2026/0257

Removal of existing septic tank and installation of package waste treatment plant with drainage field.

Norfield House, Bank End Lane, High Hoyland, Barnsley S75 4BB

Existing layout 1:500

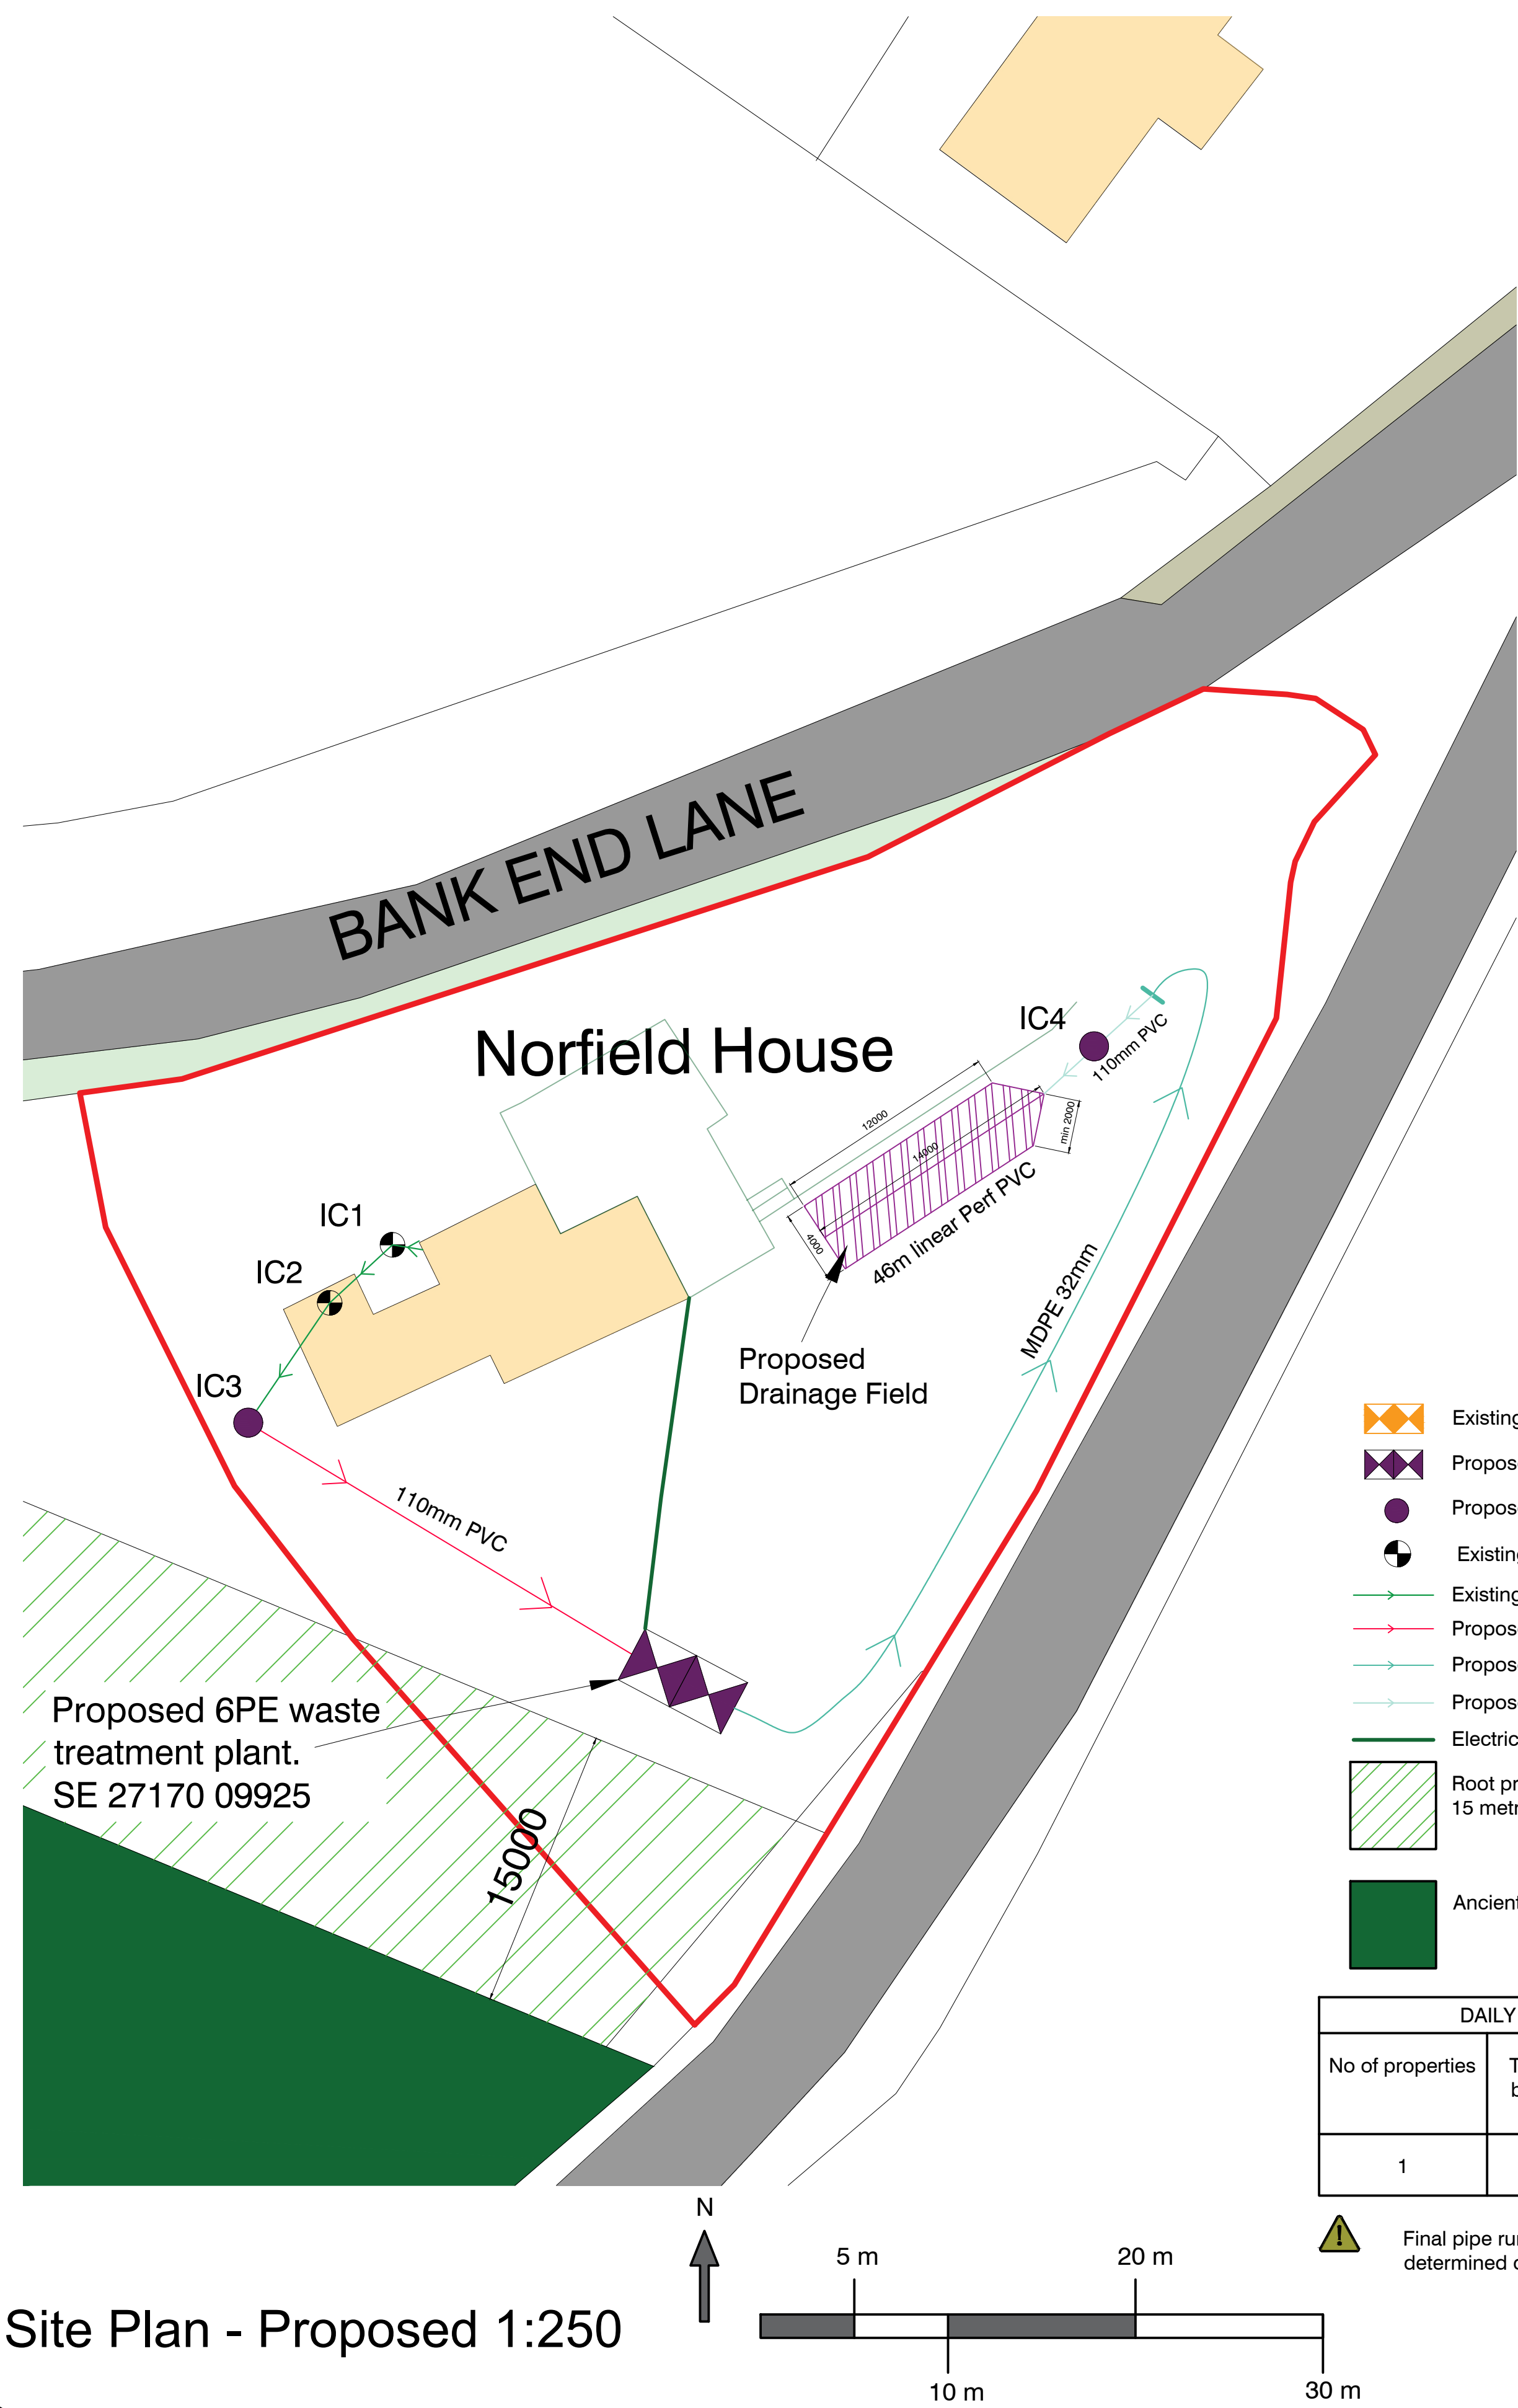
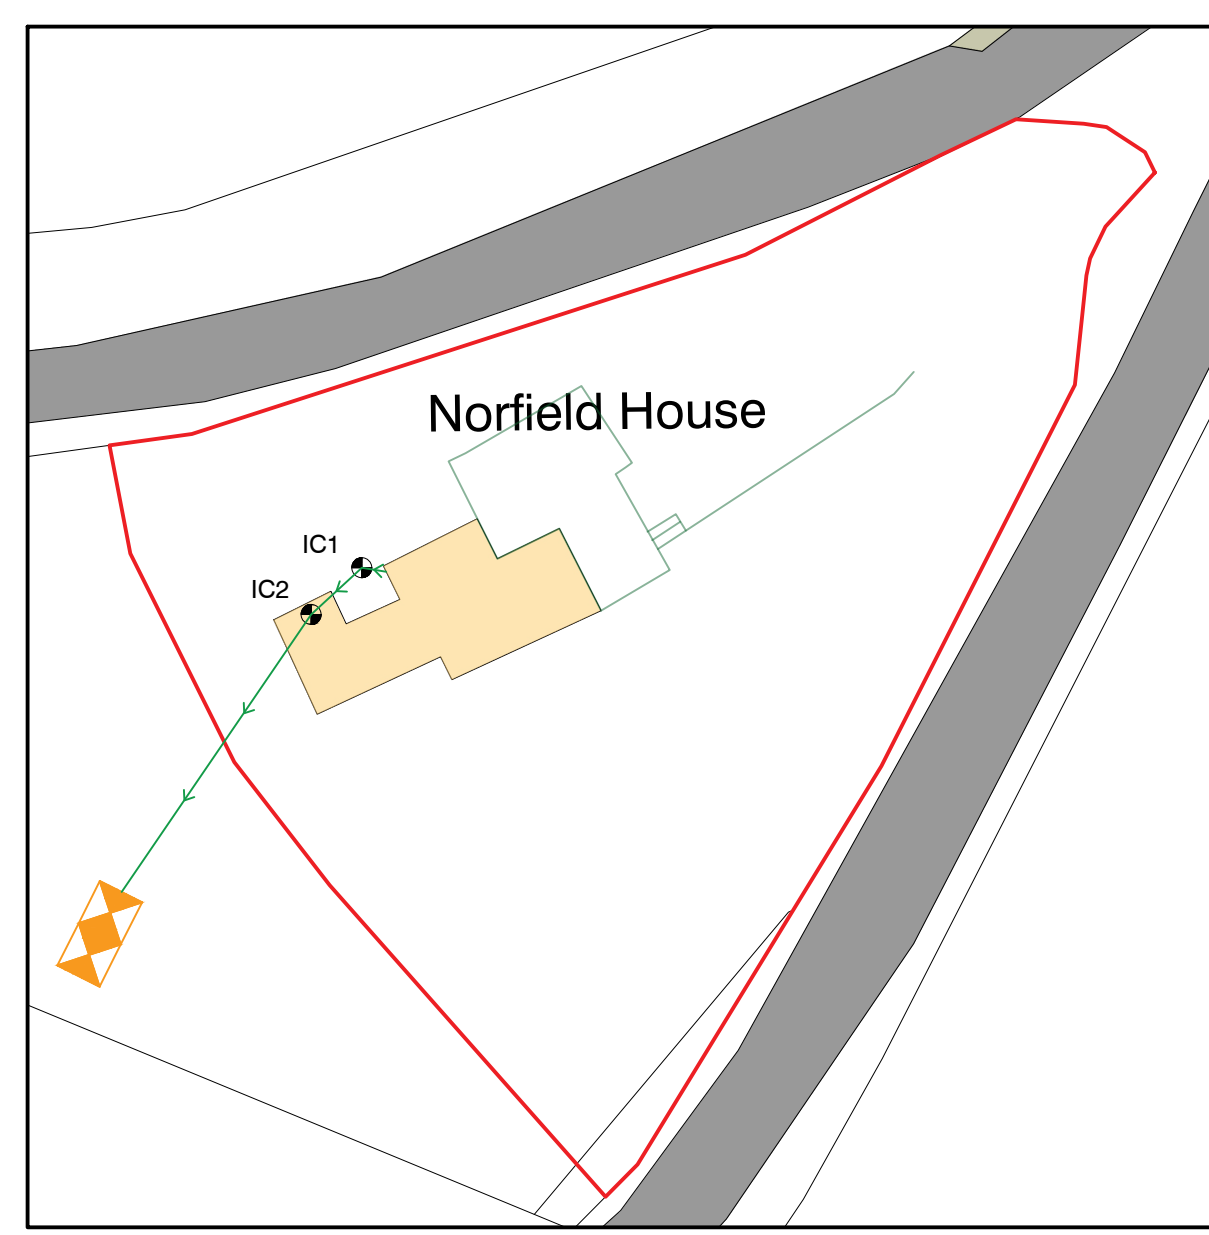
The Biodiversity Officer raised initial concerns regarding the proximity of the system to the adjacent ancient woodland. Government guidance recommends that there should be a buffer of at least 15m from the boundary of the woodland to avoid root damage. As such the proposed siting has been amended and the system is now over 15m from the boundary of the woodland.

The Biodiversity Officer has no objection to the amended proposal and it is not considered the proposal would cause ecological harm.
